# CITY OF ALBUQUERQUE

RE: **Monterey Baptist Church**  
**12501 Lomas Blvd NE**  
**Request 90-Day Temporary C.O. - Approved**  
**Engineers Stamp Date 6/17/15 (J22D012A)**

Existing cobble swale that drains to pond, see sheet 2

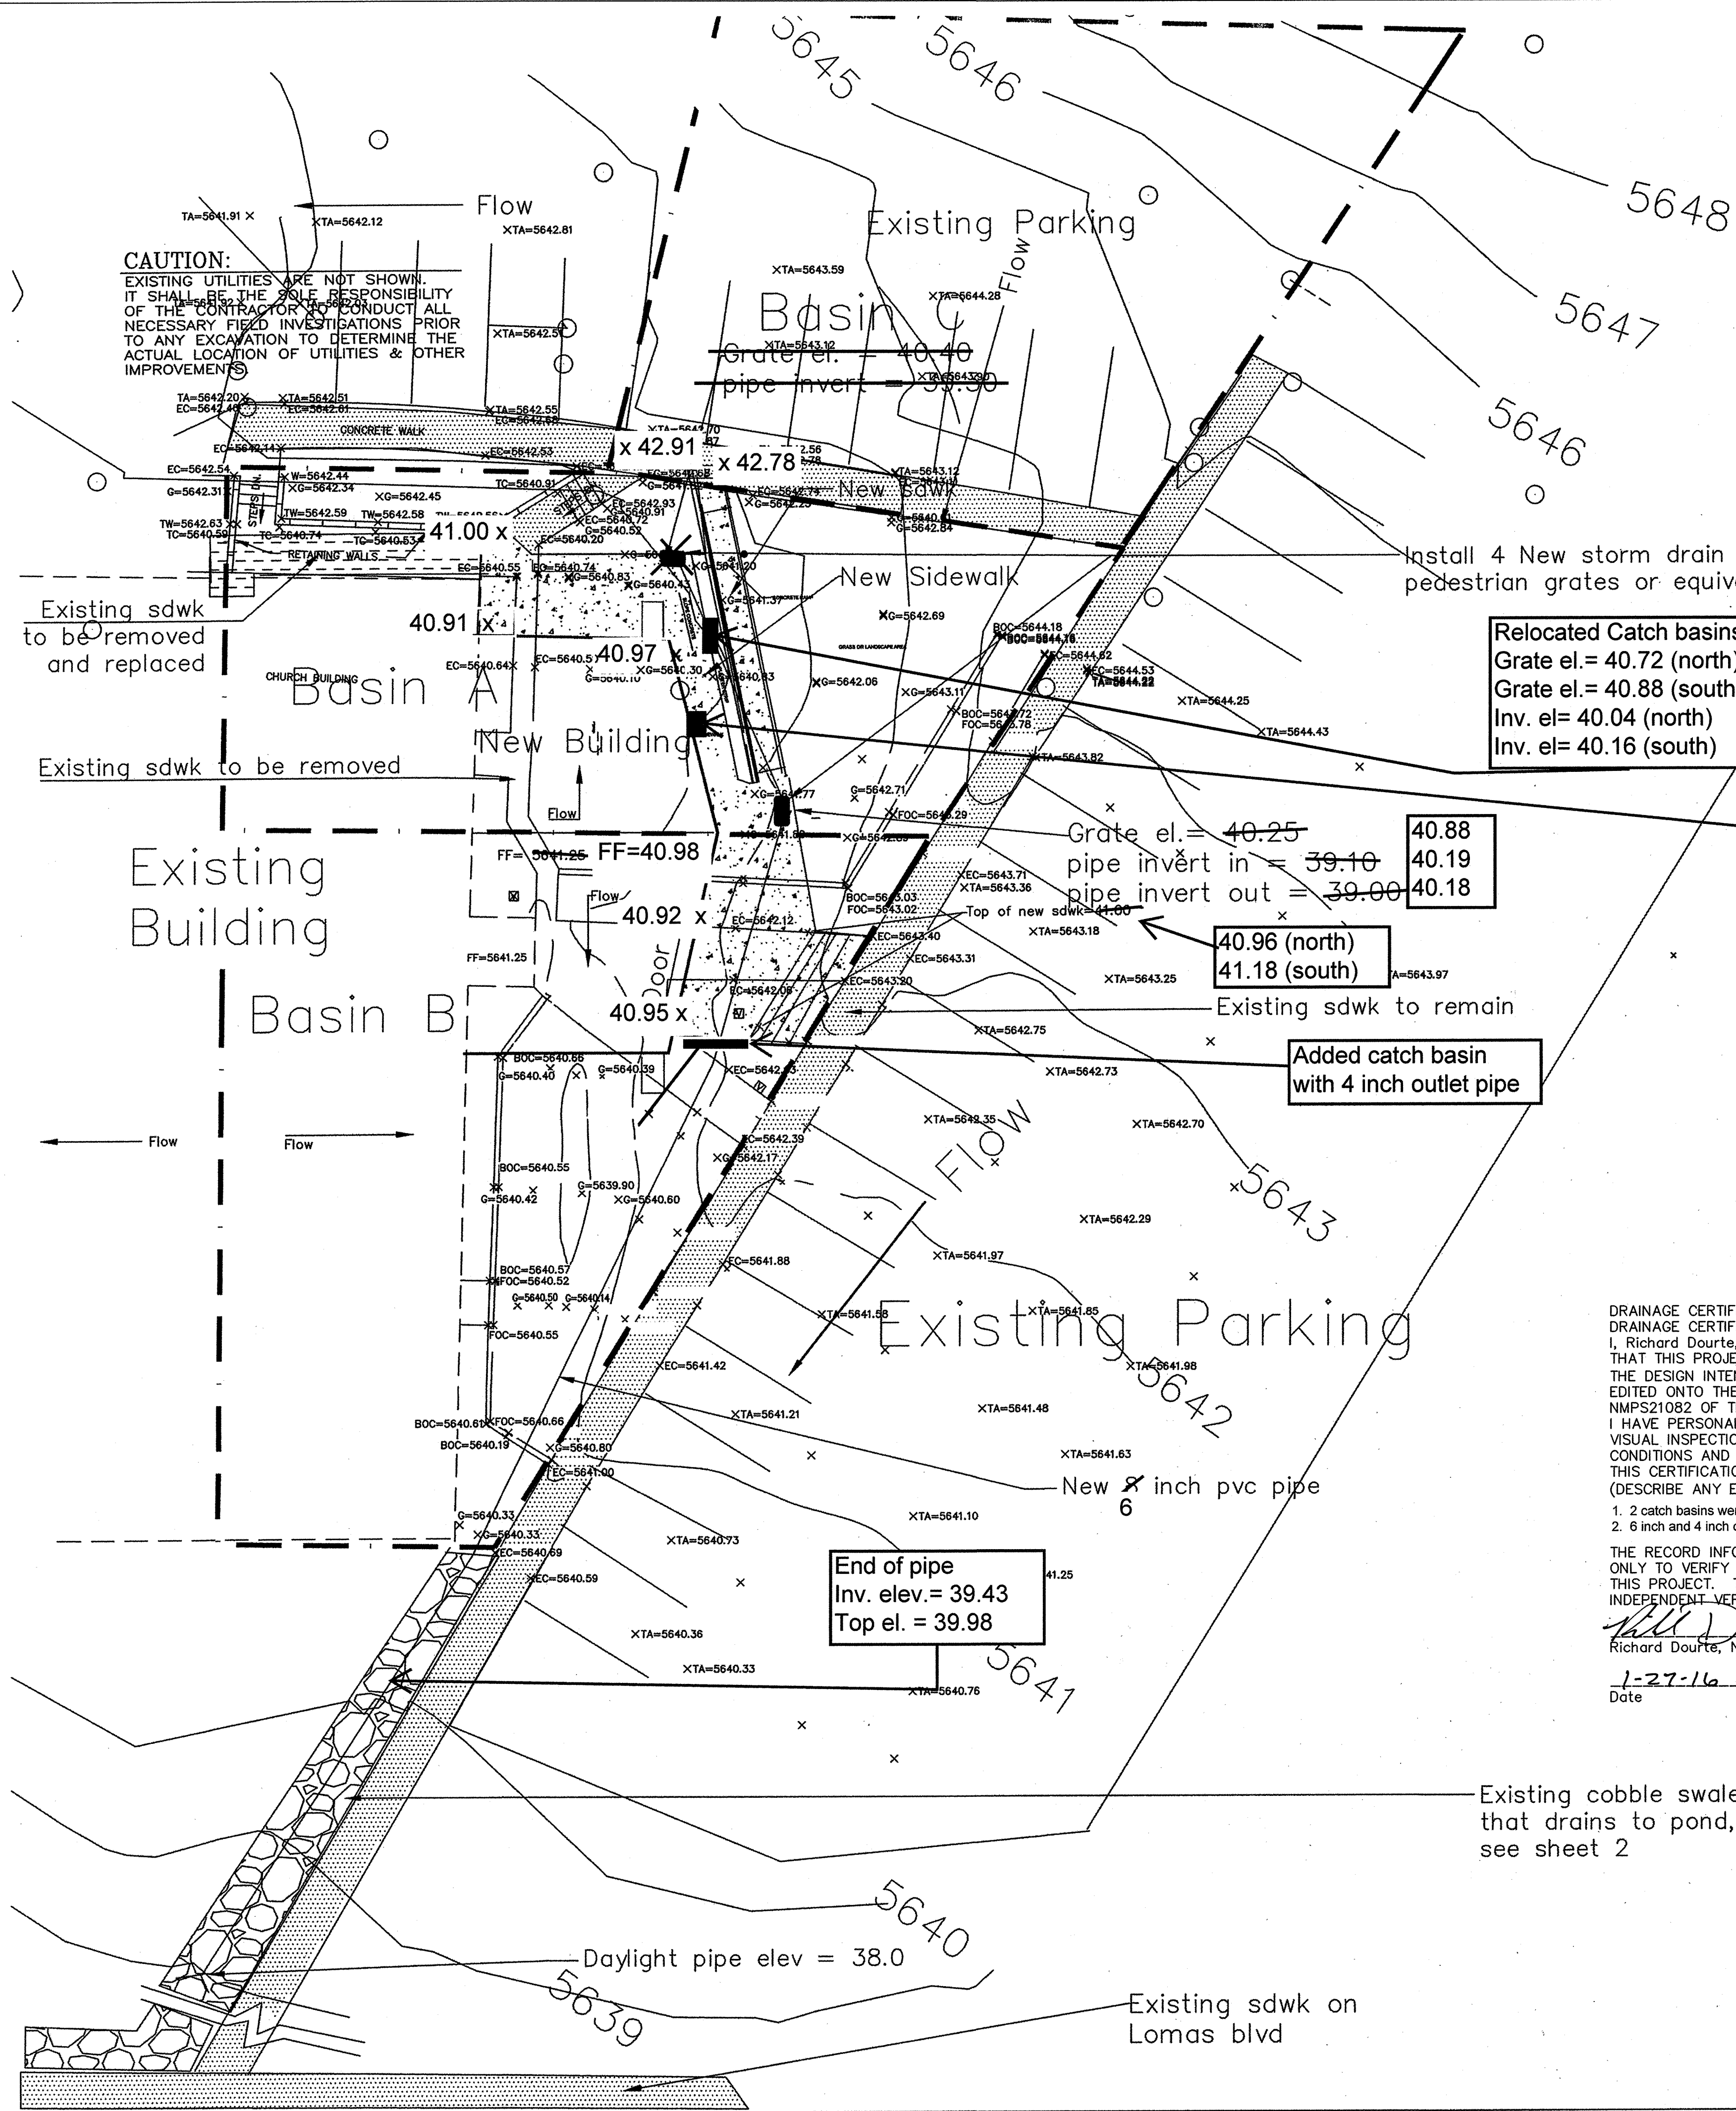
- A portion of the existing cobble swale that connects to the new pond has been removed and is missing.

After a field visit to the site yesterday, I can verify that there is a swale on the north side of the sidewalk along Lomas. The swale is not lined or has there been stone place in this swale.

Please issue a temp. CO for this building until the swale has been lined and stone has been placed. Some regrading of the swale entrance to the pond may be needed...
